**Application to Discharge Conditions attached to Listed Building Consent 92/03645/LBA
The Horse Shoe Bar, 17-19 Drury Street, Glasgow, G2 5AE**

We are pleased to enclose details to discharge conditions 01, 03 and 04 of listed building consent 19/03645/LBA dated 14th May 2020.

SCALE	DRAWING NO
1:50 @ A1	JMDA 1486/112
DATE	
27.11.19	
DRAWN BY	
ES

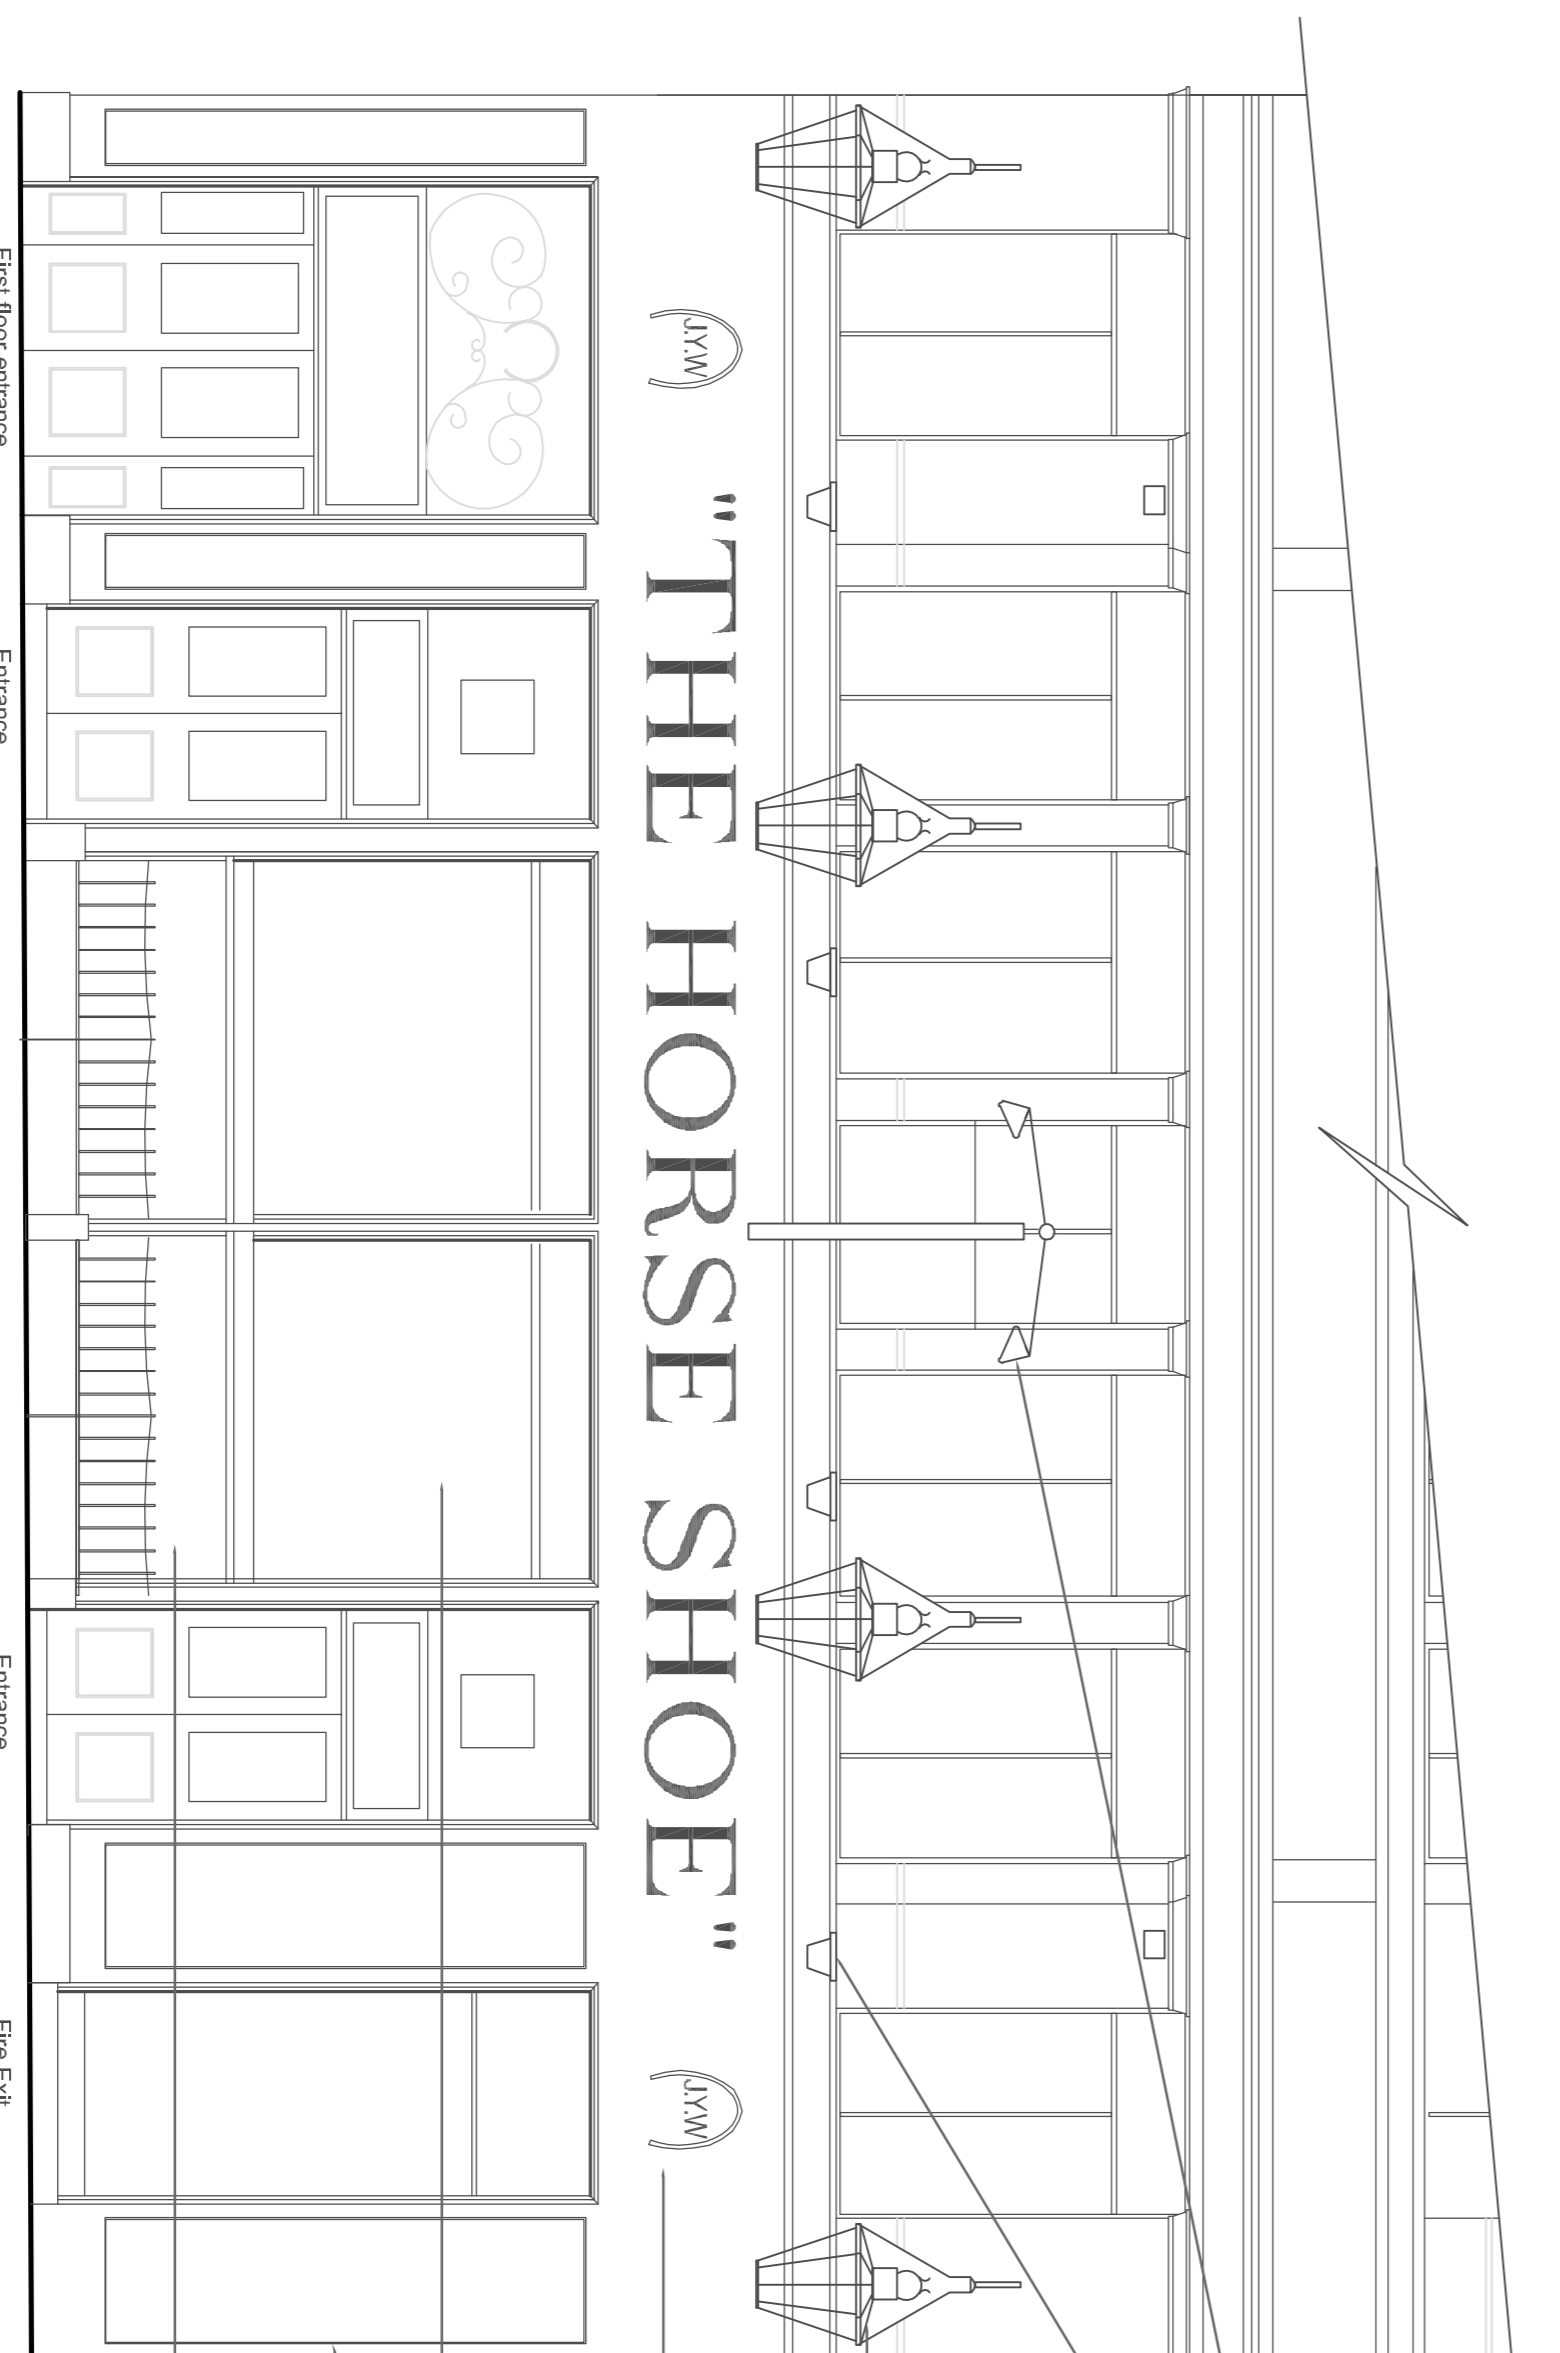
Having reviewed the lighting plan, it does appear as though the number of fittings will be reduced. It may be worthwhile discussing with the applicant whether the proposed lights can be sited more discretely under the cornice?"

“For the avoidance of doubt, the proposed floodlights on the frontage are hereby not approved. Further details of the proposed lighting installation, including the type, dimensions, locations and colour of fittings, cable routes and associated electrical equipment shall be submitted to and approved in writing by the Planning Authority prior to being installed on the building”.

“All external colours shall be approved in writing by the Planning Authority before they or any relevant materials are used on the site”.

We include approved External Elevation Drawing 1486/112, which includes an image showing the external elevation and existing lighting. The four ‘carriage lamps’ are being retained as are all cable routes and associated electrical equipment.

The only lighting items that are being changed are the small light fittings that are positioned above the fascia panel. As part of the pre-application process, the Applicant had originally proposed to replace these fittings with a single trough light (which was the same length as The Horse Shoe letters below). The Conservation Team, however, indicated that they would prefer to see the existing fittings upgraded and replaced.

Details of the proposed replacement fittings, which will be in the same position as the existing units shown on approved Drawing 1486/112 are attached. It is proposed to use the 50W Alhaline Asymmetrical units.

As is detailed on approved Drawing 1486/112, the main building masonry will be painted in Dulux Heritage Ravens Flight Weathershield Diamond Matt Finish with the existing gold decorative moulding remaining that colour. The red tiling, below the two shop windows, will be retained.
